Latigo Preserve Filing No. 10
Traffic Impact Analysis
PCD File No. SF-21-36
(LSC #S214500)
March 31, 2022

LSC Responses
to comments on
this March 31,
2022 TIS report.

**Site Context Map**  
Latigo Trails Filing 10 (LSC #S214500)

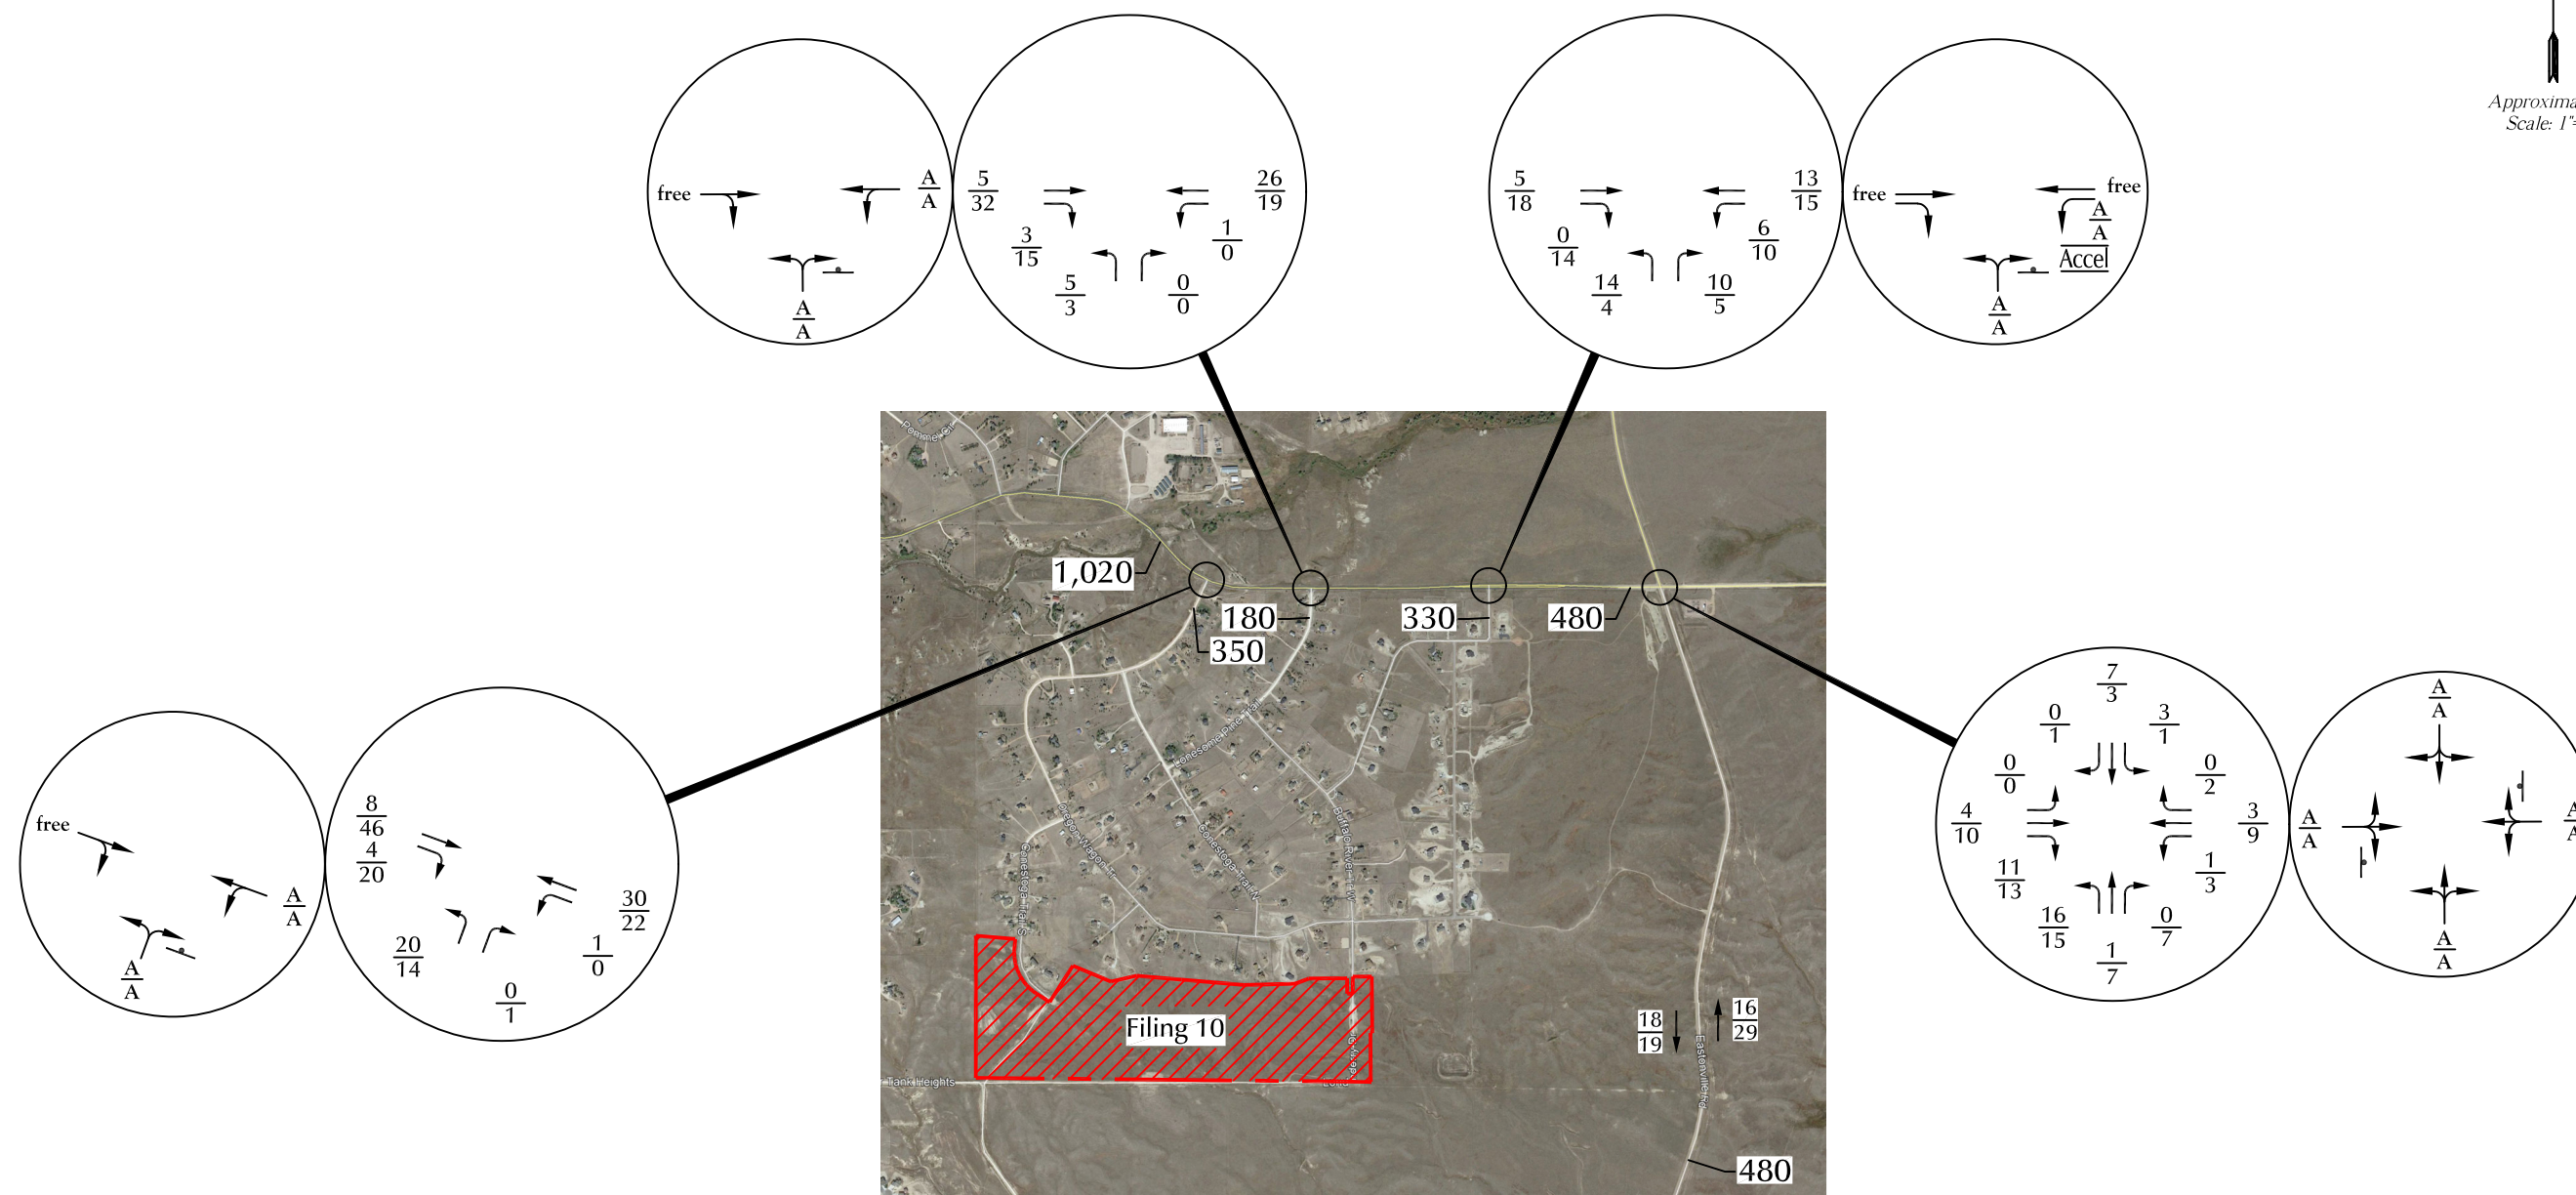
Why has this been revised to Filing 10 only? a. If the application for the area previously identified as Filing 9 has been withdrawn then this project needs to be renamed from Filing 10 to Filing 9. b. If Filing 9 application has not been withdrawn then trip generation estimates needs to include Filing 9

Response: Filing 10 has been renamed to Filing 9. The decision to only include Filing 9 at this time is the applicant's decision.
